CITY OF PORTLAND, MAINE

October 28, 2016

Project Name: 23 Ocean Avenue Mixed Use
Address: 23 Ocean Avenue
Applicant: 23 Ocean Avenue Associates, LLC
Planner: Nell Donaldson

Project ID: 2016-150
CBL: 129 G001001

C1

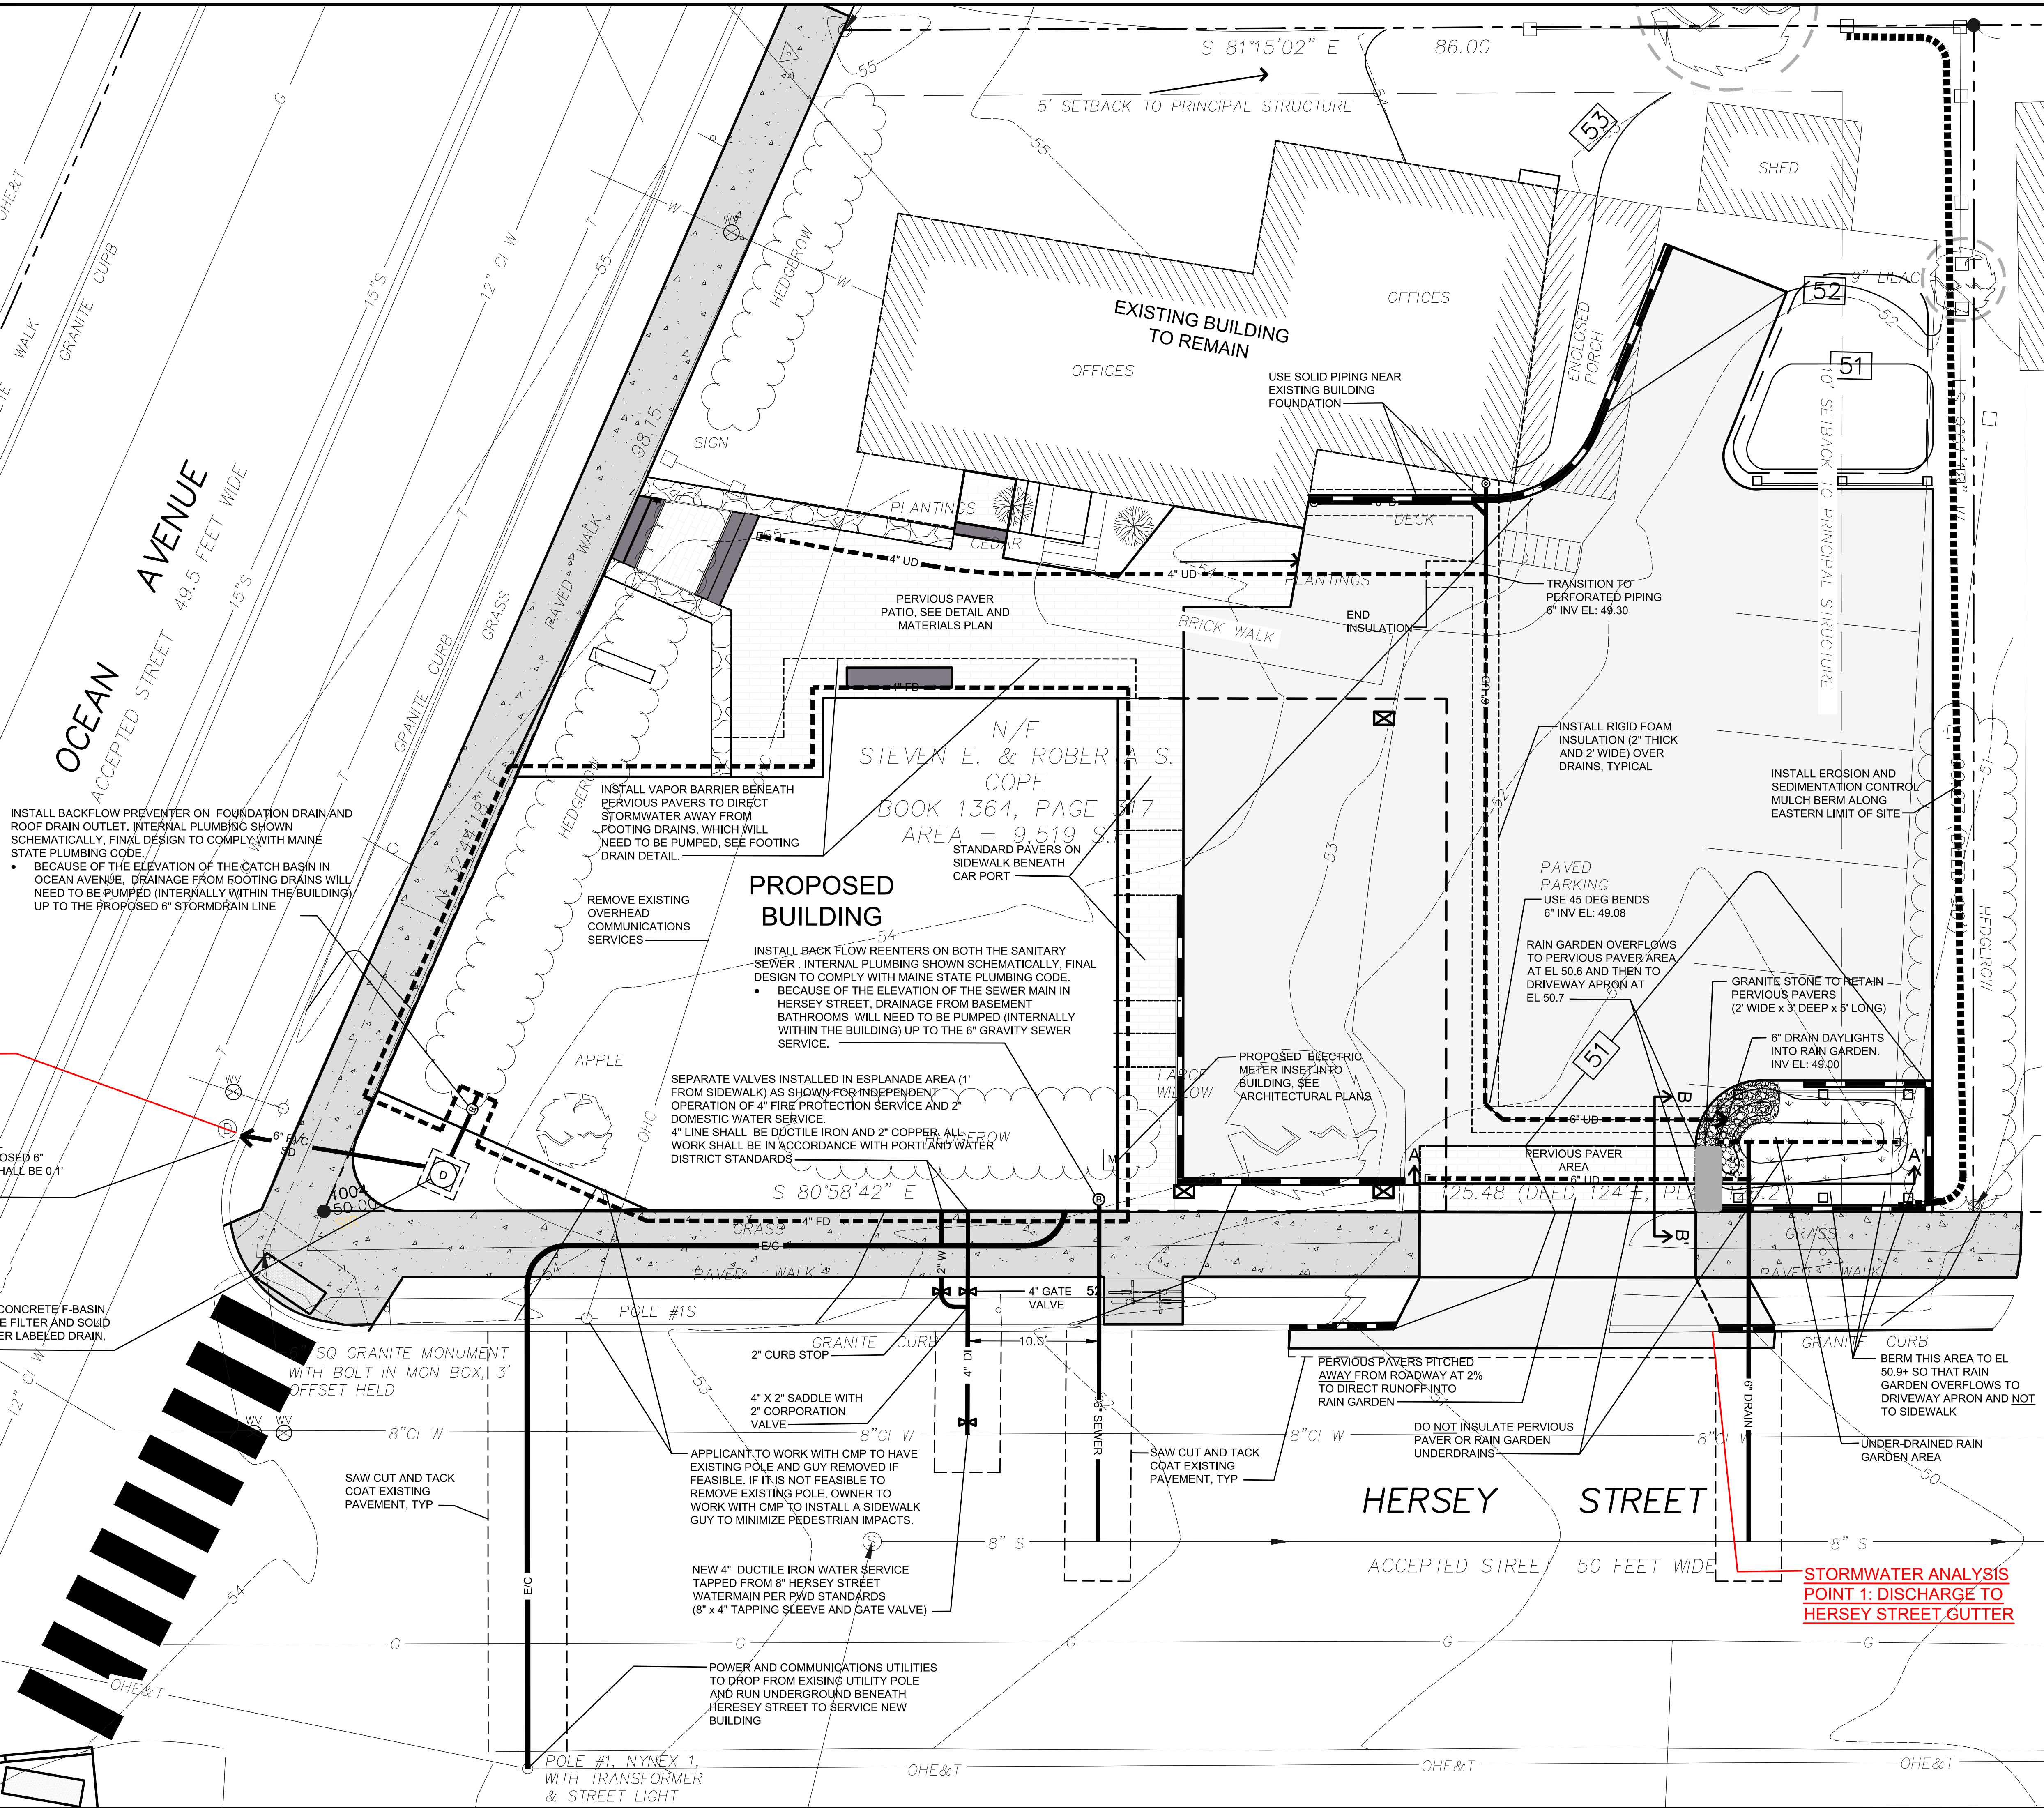
At the Department of Public Works’ request, the applicant has modified their final drainage plan to direct runoff from the proposed building’s roof to an existing catch basin in Ocean Avenue, which, as a product of future city plans, would ultimately be connected to a new separated stormwater system. This runoff would be treated with a roof drain cartridge filter. The remainder of the site, including the existing building roof and the parking area, would drain to a rain garden, which would outlet to the combined sewer in Hersey Street and overflow to a pervious paver system in the driveway apron. The applicant writes that, under the proposed plan, “the peak flow rates discharging to Hersey Street will decrease for all storm events. This is because both the total area and impervious area draining to Hersey Street are proposed to decrease [under the post-development condition]” (*Attachment J*).

Ms. Swett has reviewed the design of this system and provided the following comments,

The project is required to include stormwater management features to control the rate or quantity of stormwater runoff from the site. The Applicant will be discharging a portion

of the site's stormwater to the combined sewer in Ocean Avenue. The site does not discharge to this location in the existing condition; however, the Applicant has discussed this condition with Public Works, and the connection will be allowed. Stormwater from the site will be collected as part of a future City sewer separation project. As a result of this connection, the stormwater discharge to Hersey Street will be reduced, providing an improvement over the existing condition on Hersey Street.

**SITE PLAN**

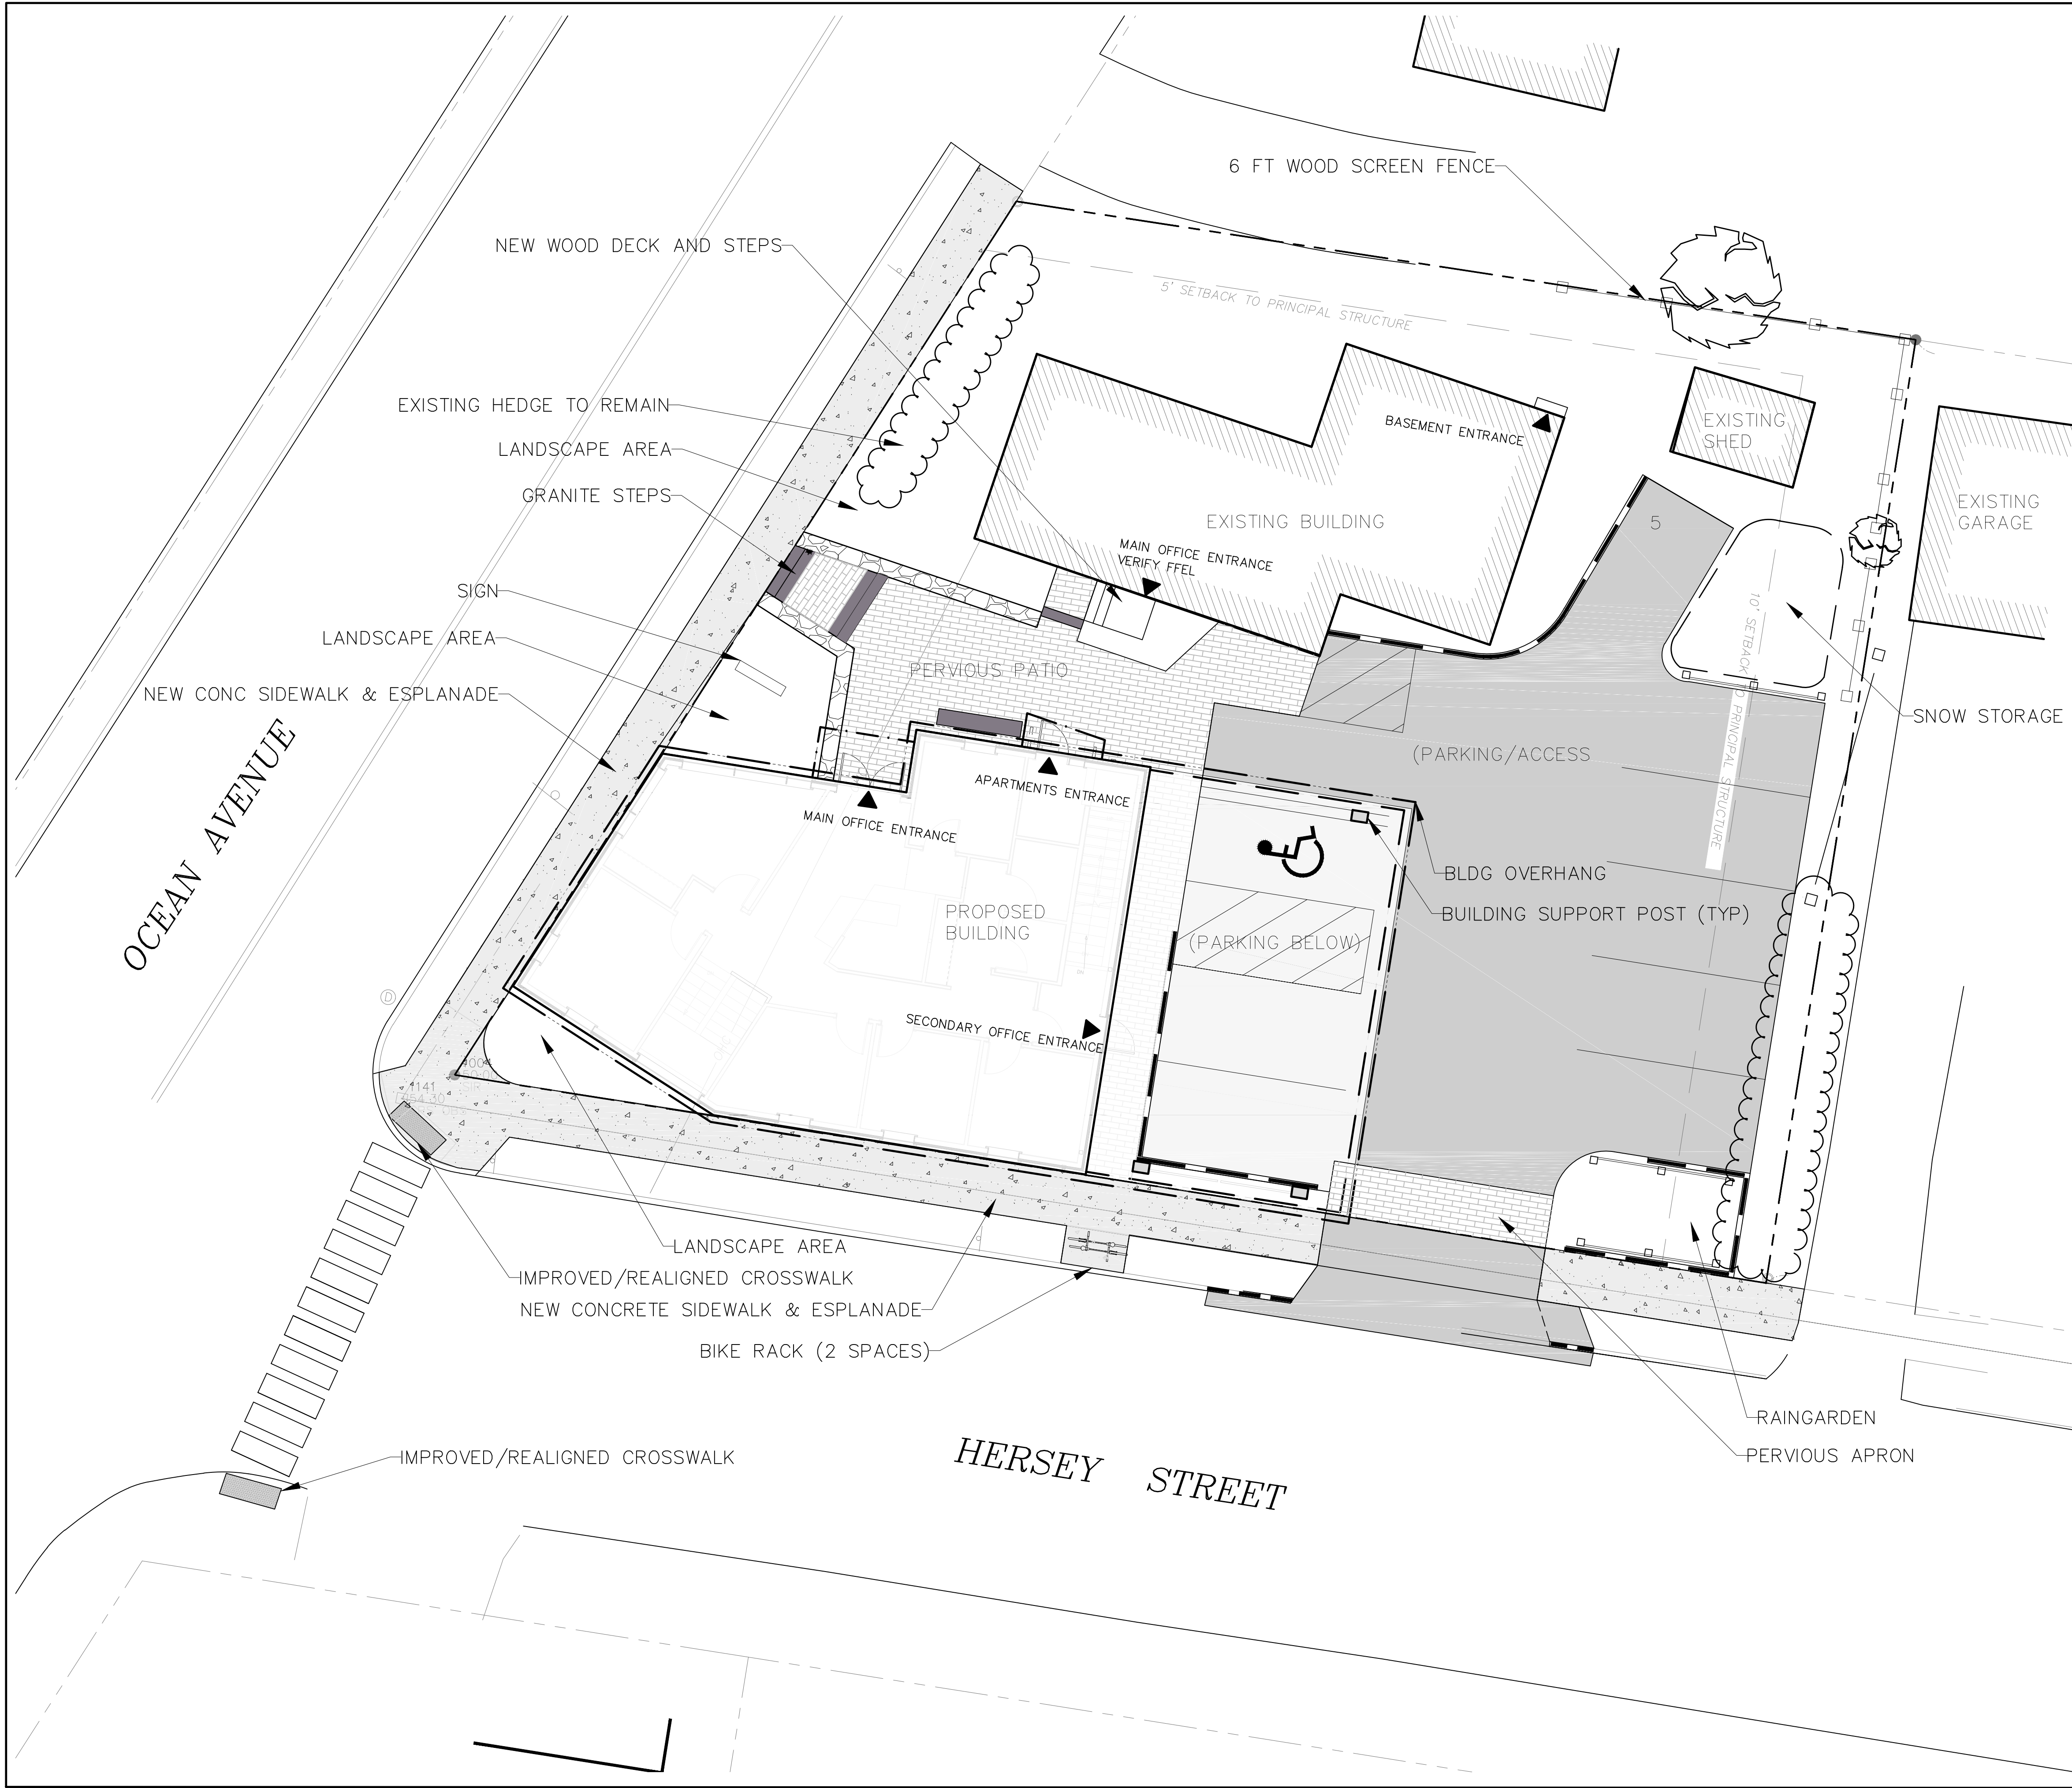
The final plans show continued use of an existing curb cut from Hersey Street for vehicular access. In the final plans, the applicant has reconfigured the parking area and reduced the number of proposed parking spaces by one as a means of eliminating the need for backing maneuvers to Hersey Street. The applicant has provided turning templates as documentation of the adequacy of the parking area design (*Plan 21*). The applicant has requested a waiver for parking lot aisle width. Mr. Errico writes,

The applicant has provided information that demonstrates onsite circulation can be accommodated.

Following a review of vehicle turning template information and revisions to the parking lot layout, I support a waiver from the City’s Technical Standards.

1. The Planning Board finds, based upon the consulting transportation engineer's review, that extraordinary conditions exist or undue hardship may result from strict compliance with the *Technical Manual* standard (*Section 1.14*) which requires that aisle width for right-angle parking be 24 feet per *Figure I-27*, that substantial justice and the public interest are secured with the proposed variation in this standard, and that the variation is consistent with the intent of the ordinance. The Planning Board waives the *Technical Manual* standard (*Section 1.14*) to allow a 21 foot wide aisle in the parking area.
